Submission to An Coimisiún Pleanála

SID Project :Shancloon Wind Farm

Reference : 323699

Date: 16 November 2025

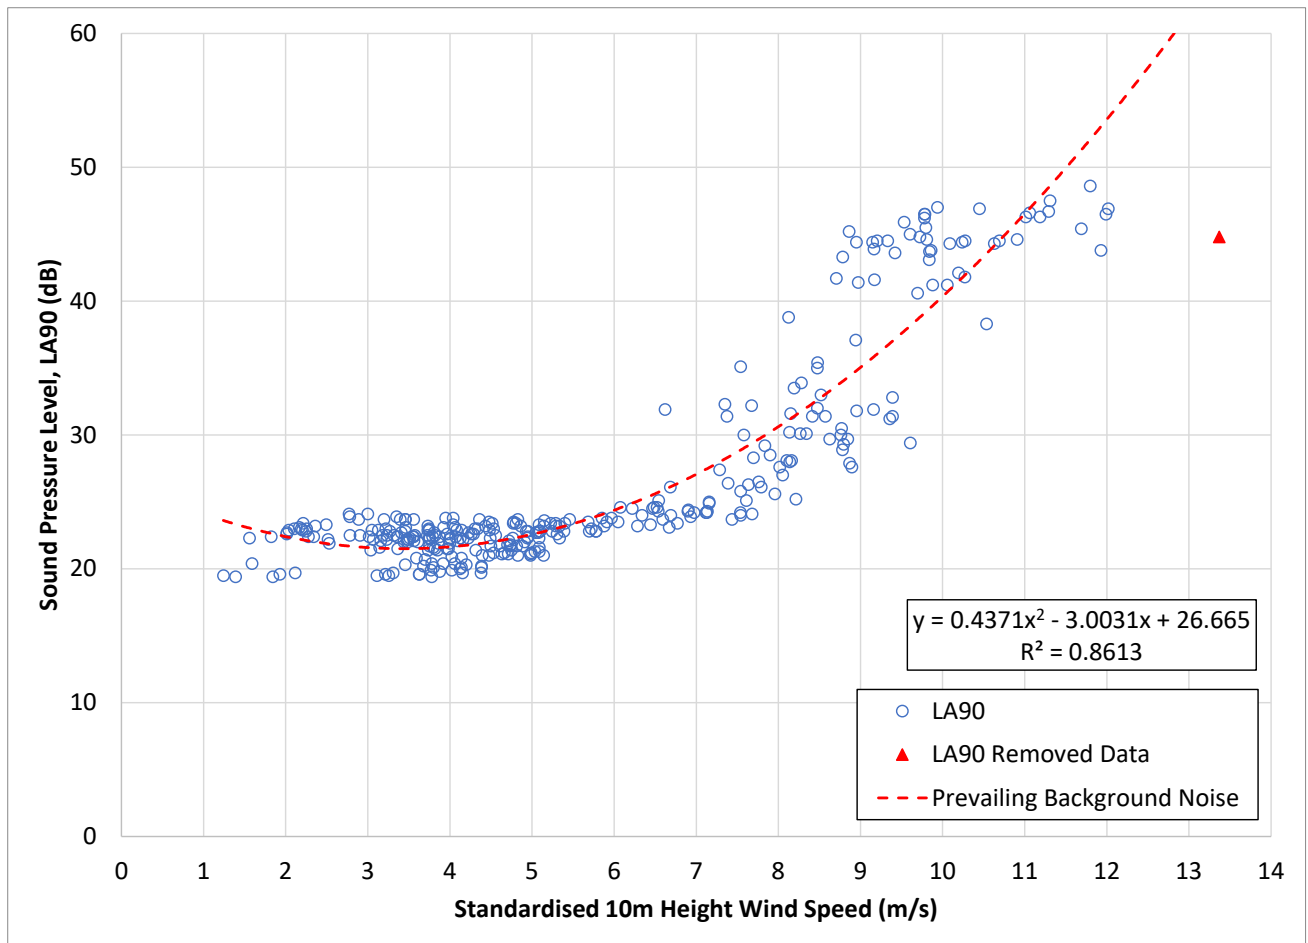
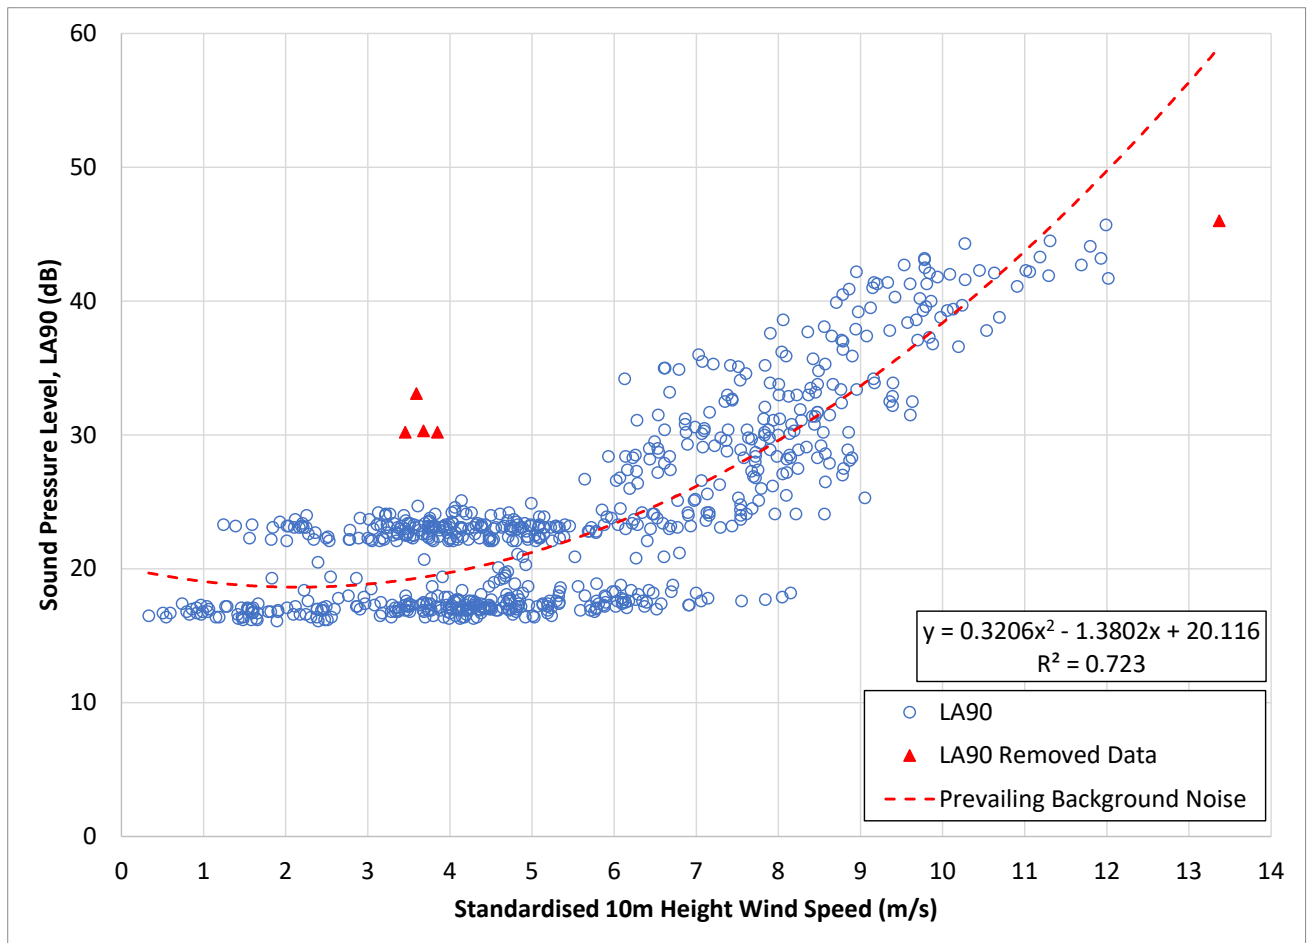
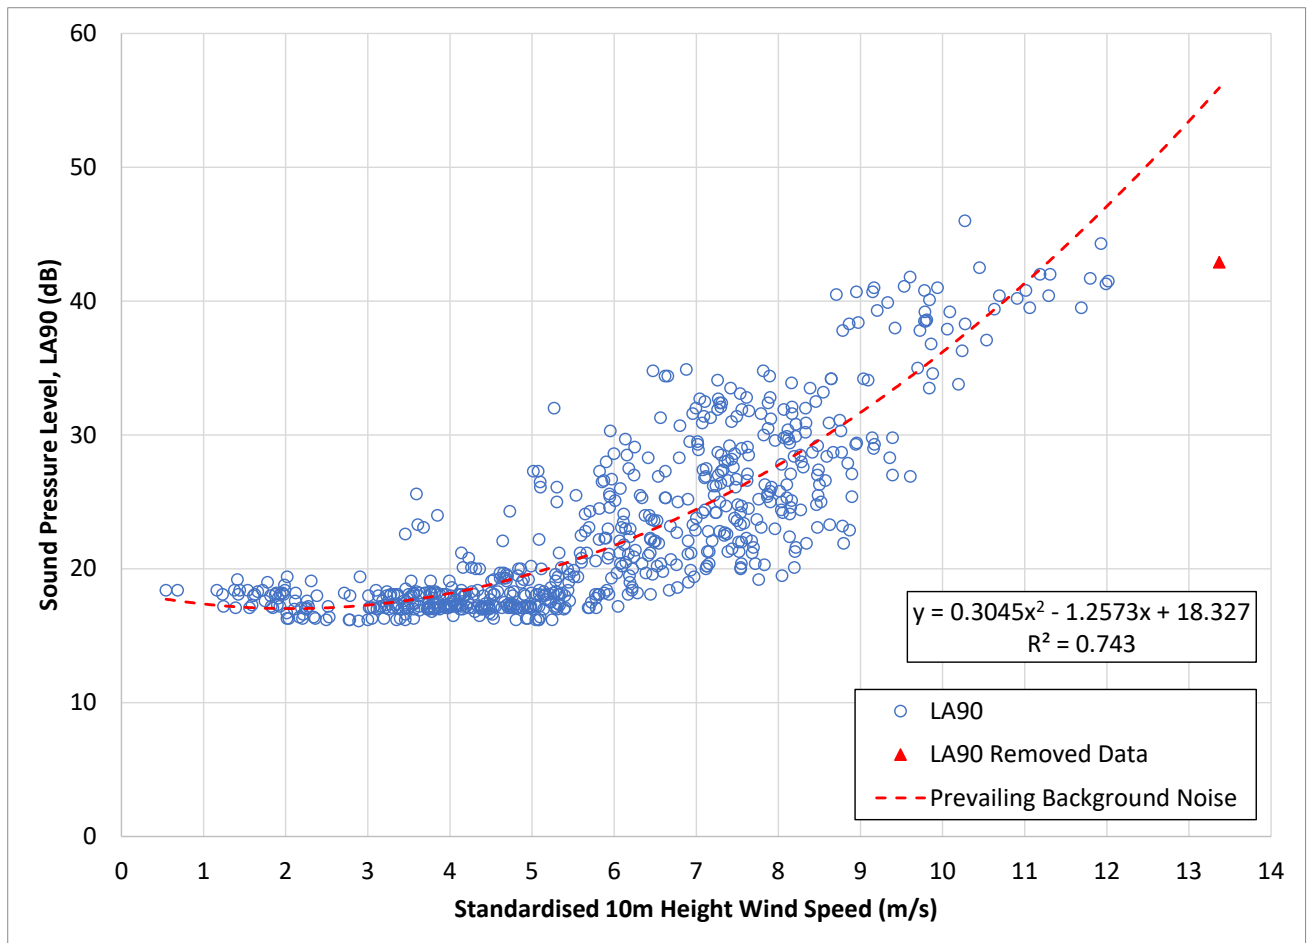
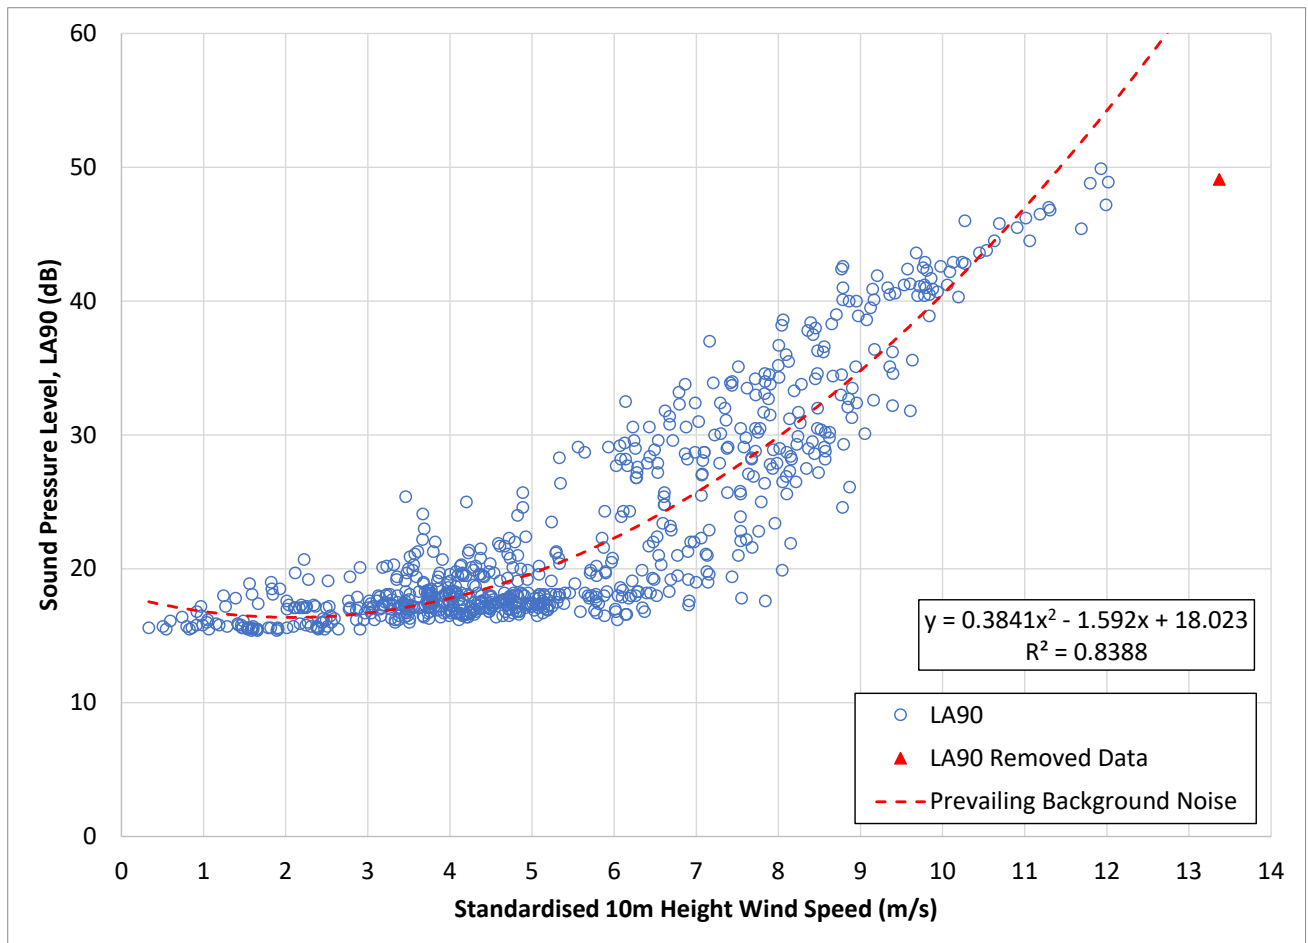
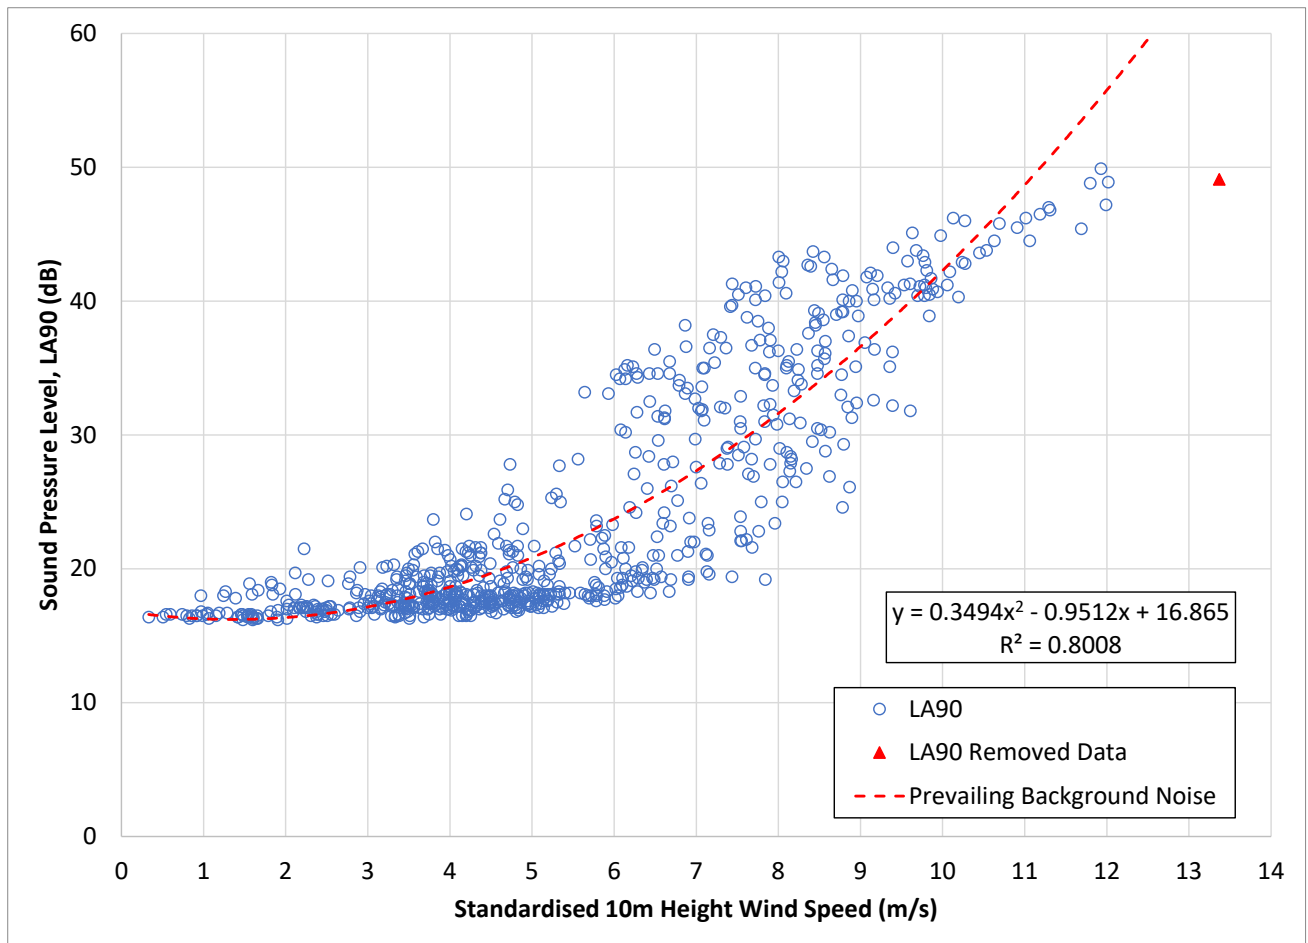
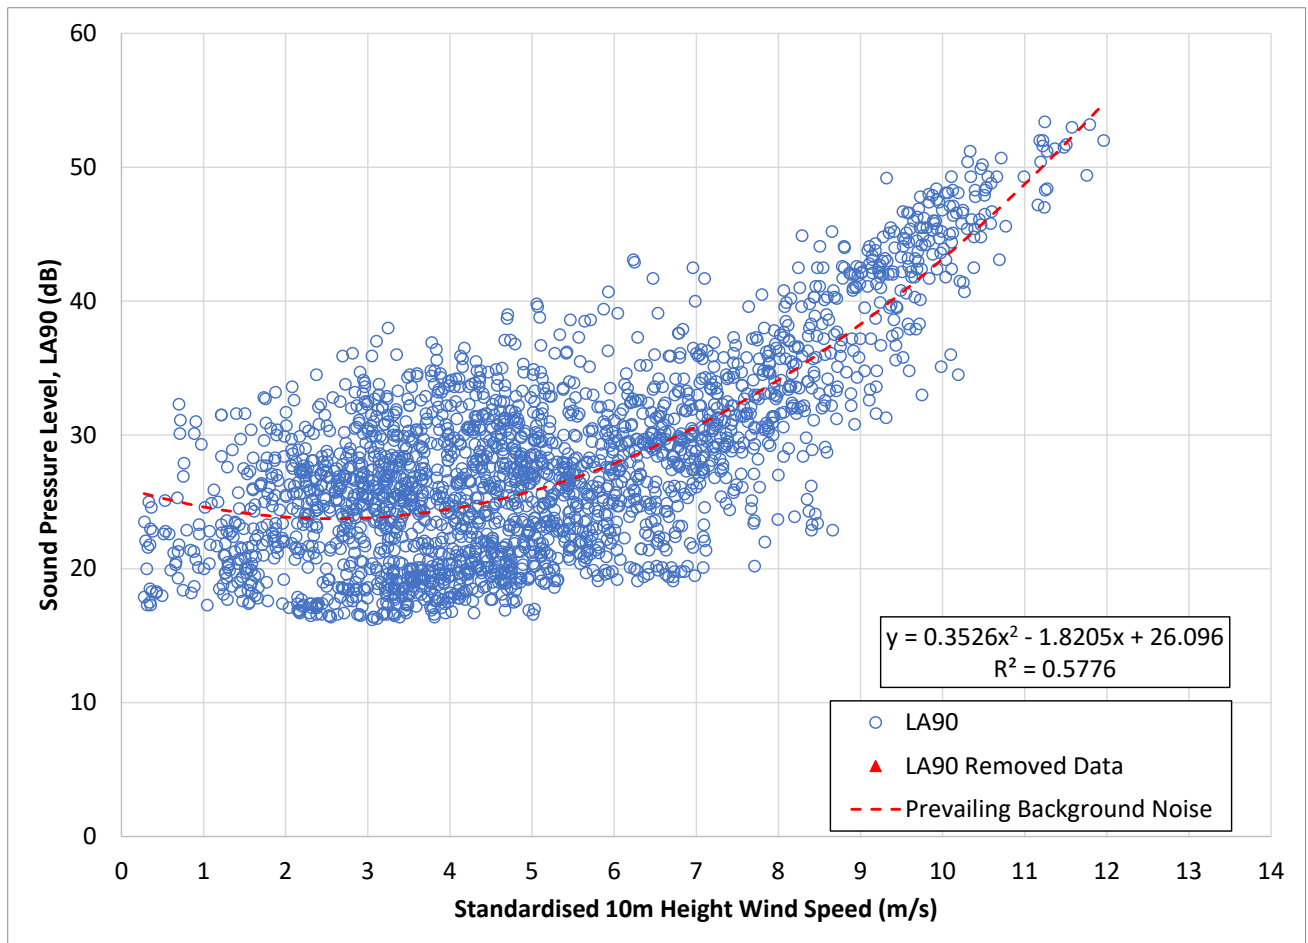
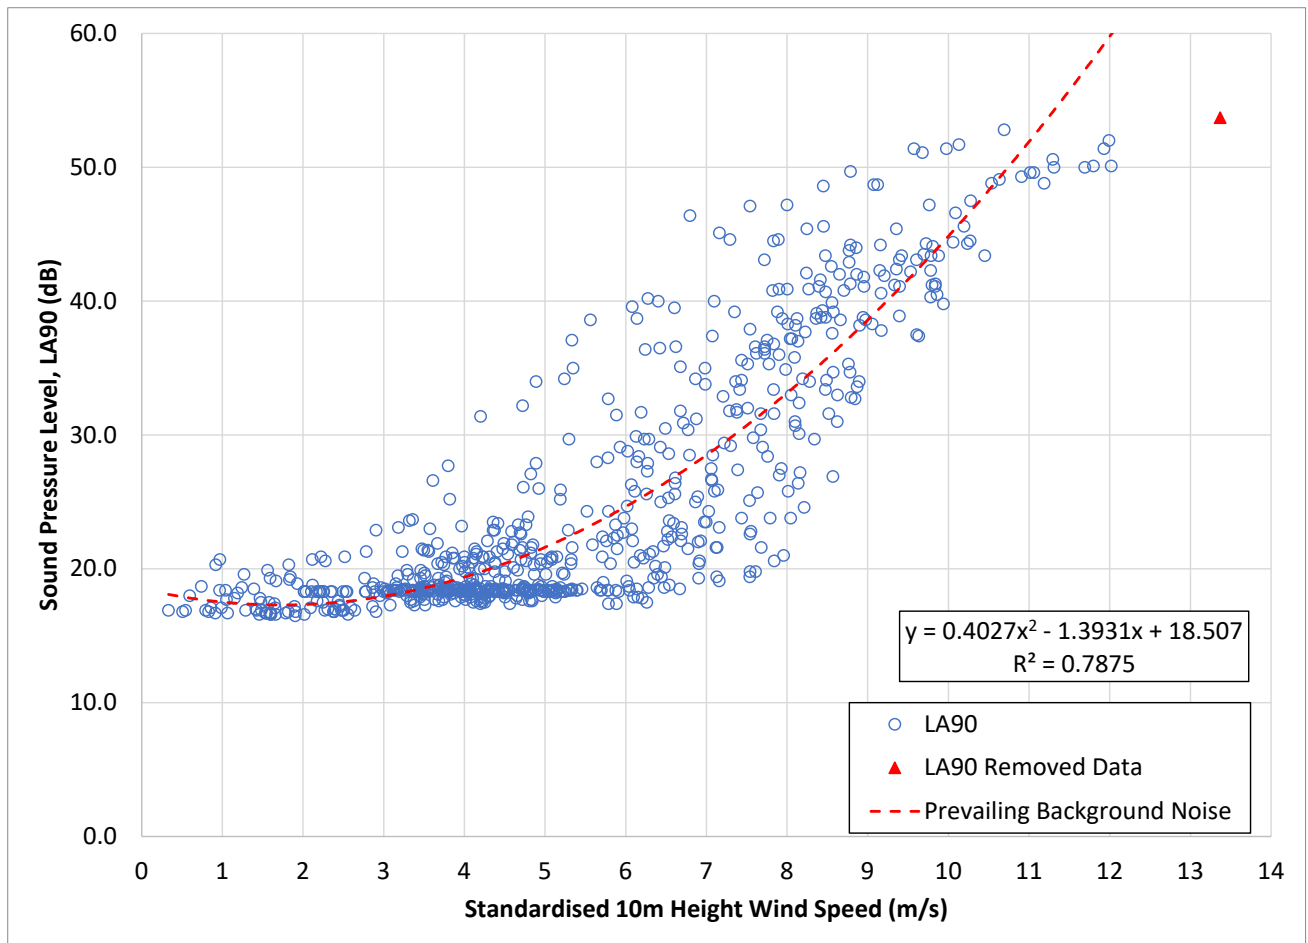
- Separation distances below 7x rotor diameter; only two turbine pairs comply (p.21).
- Noise limits exceed permissible nighttime levels; cumulative turbulence effects ignored (pp.36–41).

- **Noise Assessment:** Nighttime permissible noise levels exceeded; cumulative effects ignored (p.36).
- **Flooding & Karst Risk:** Impermeable surfaces and karst collapse risks underestimated (p.51).
